**Consultation Response from: KC Environmental Health (Pollution & Noise Control)**

2024/92016 - Land Adjacent, The Shears, 201, Halifax Road, Hightown, Liversedge, WF15 6NR

Discharge of details reserved by conditions 5 (materials), 6 (boundary treatment), 7 (Phase I Desk Top Study), 12 (bin storage/locations), 13 (evc) on previous permission 2023/93657 for erection of two detached dwellings with detached garages; alterations to public house with dwelling above to form one dwelling; erection of single and two storey extension to 201a Halifax Road

**Date Responded:**  
 19<sup>th</sup> September 2024

Drawing No.
3571 (0-) 15

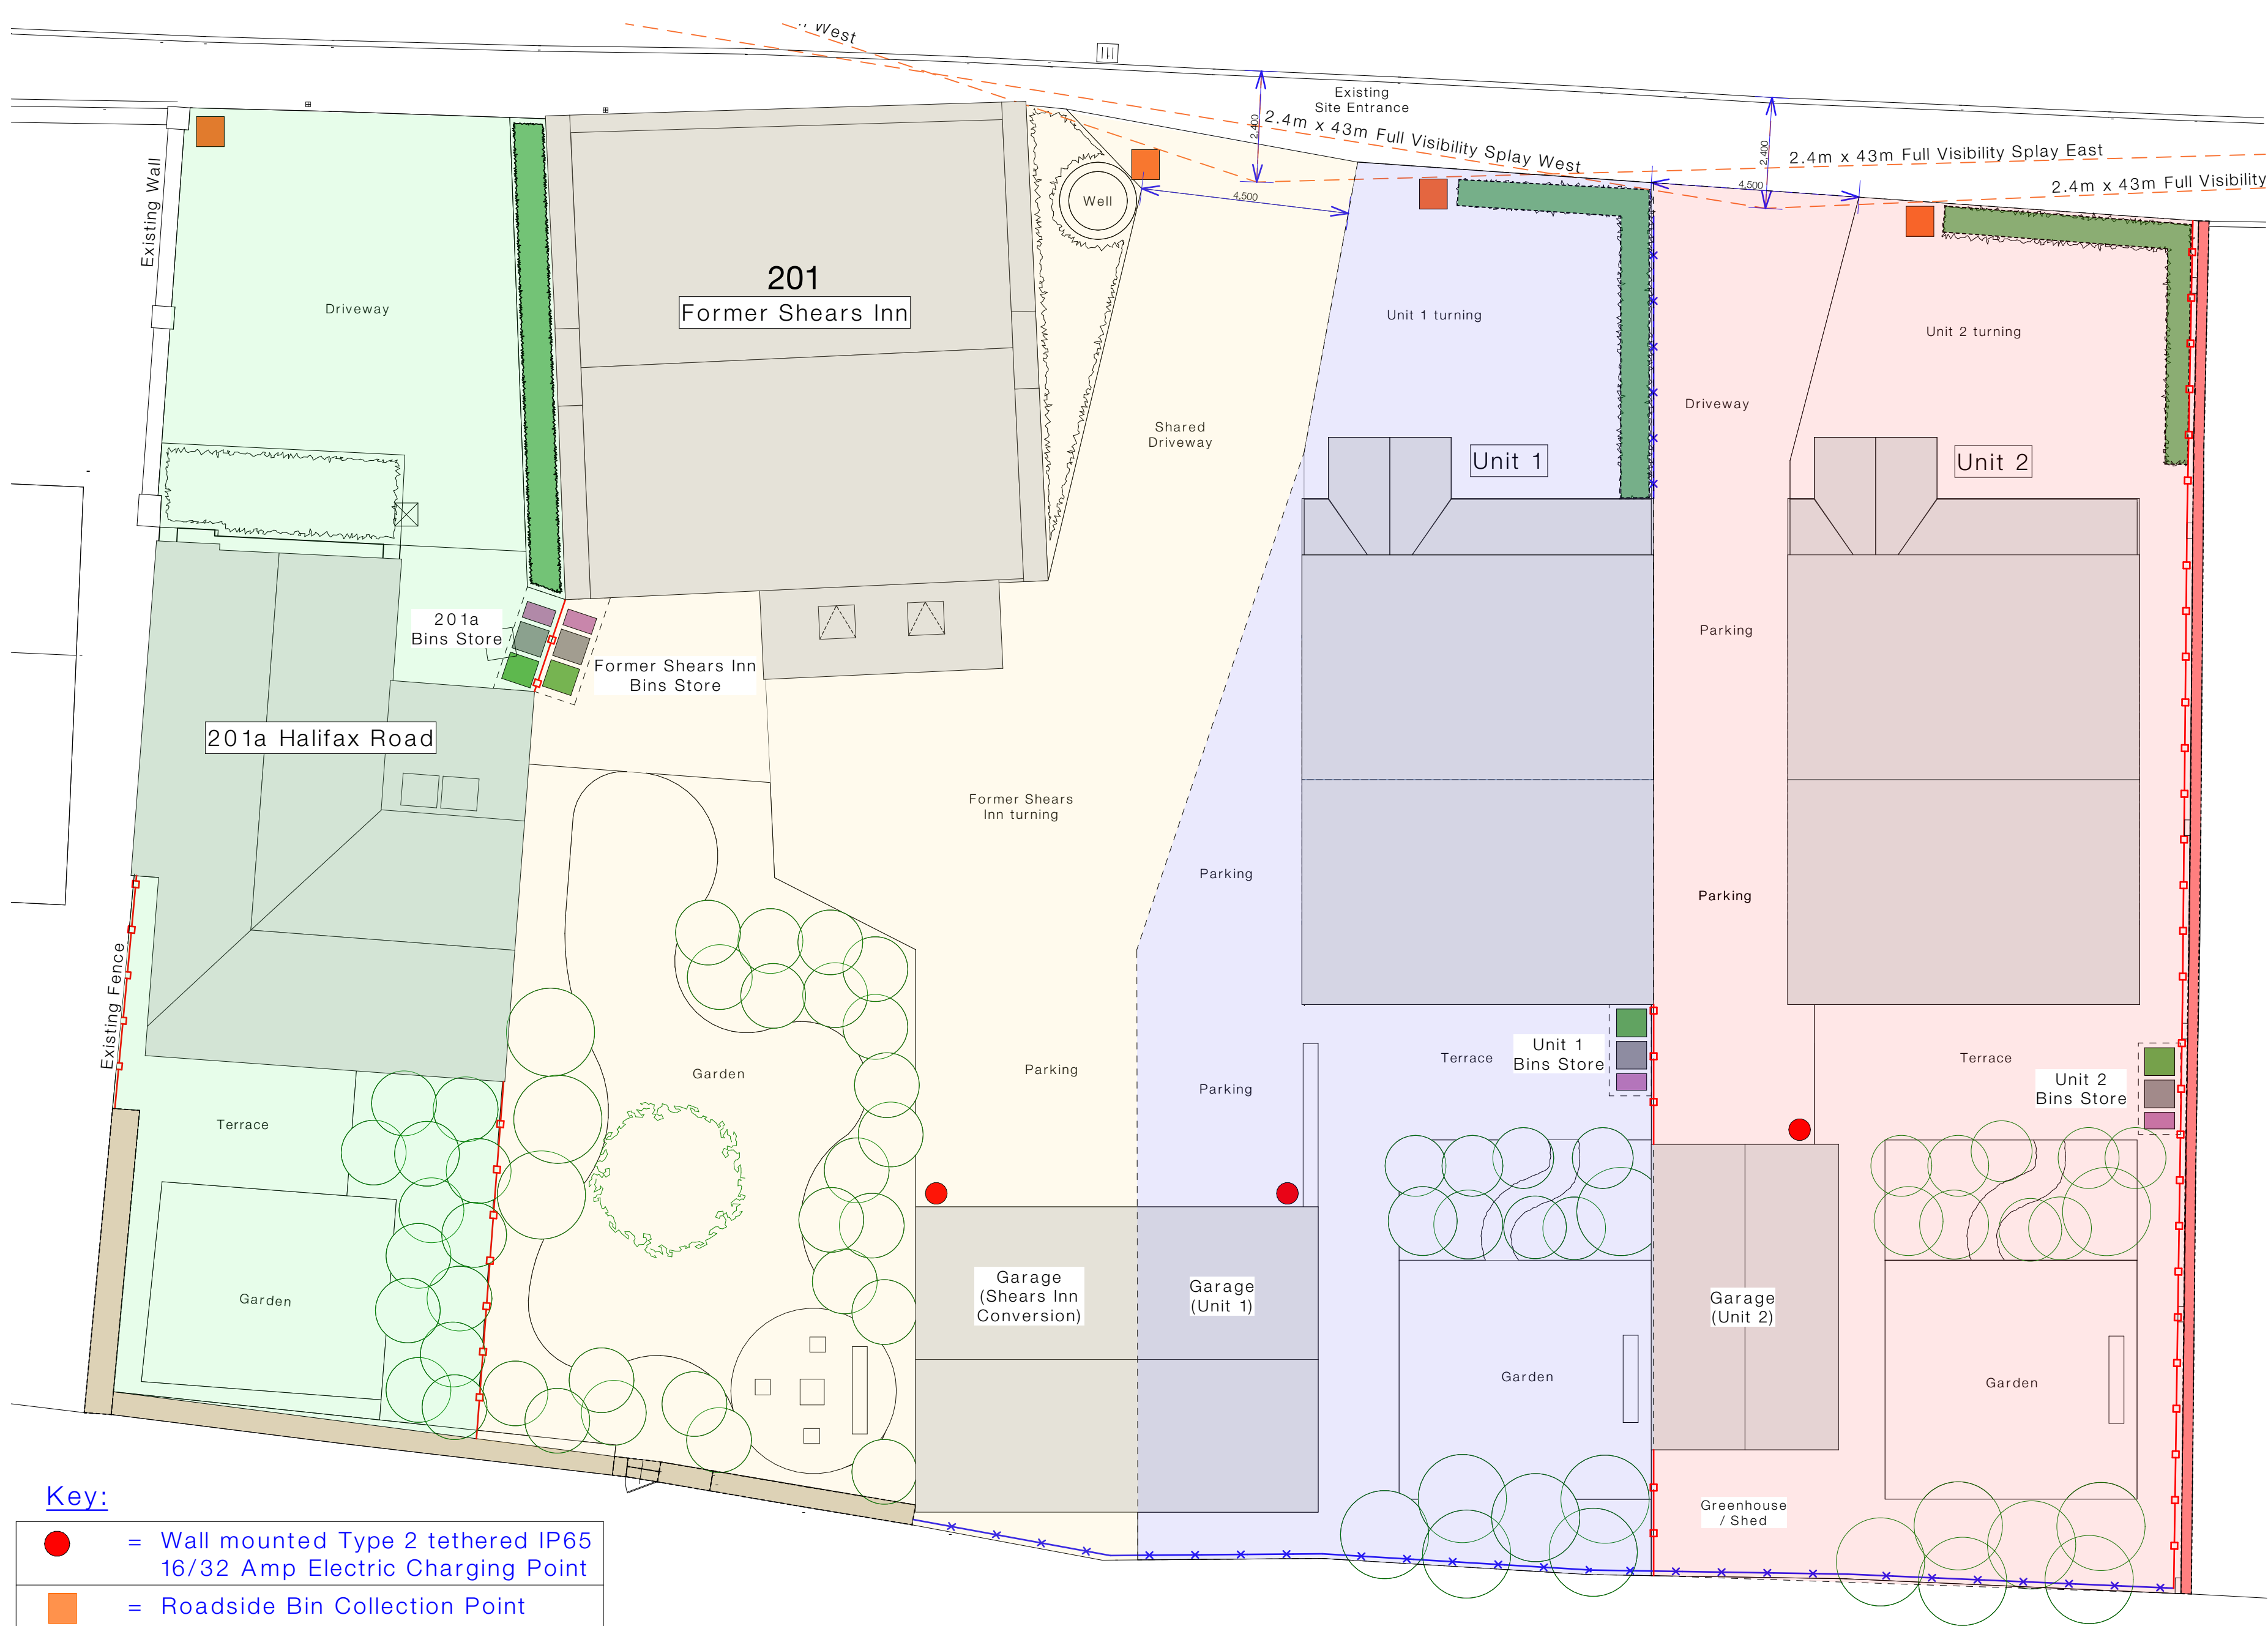
Drawing 3571 (0-) 15 by One17 Design dated July 2024 details the electric vehicle charging points specifications. These are sufficient for the technical aspects of the condition. Any charging point must also meet building control requirements. Overall, we accept the information and however, the condition must remain in perpetuity.

We accept the Drawing 3571 (0-) 15 by One17 Design dated July 2024, however, the condition must remain in perpetuity.
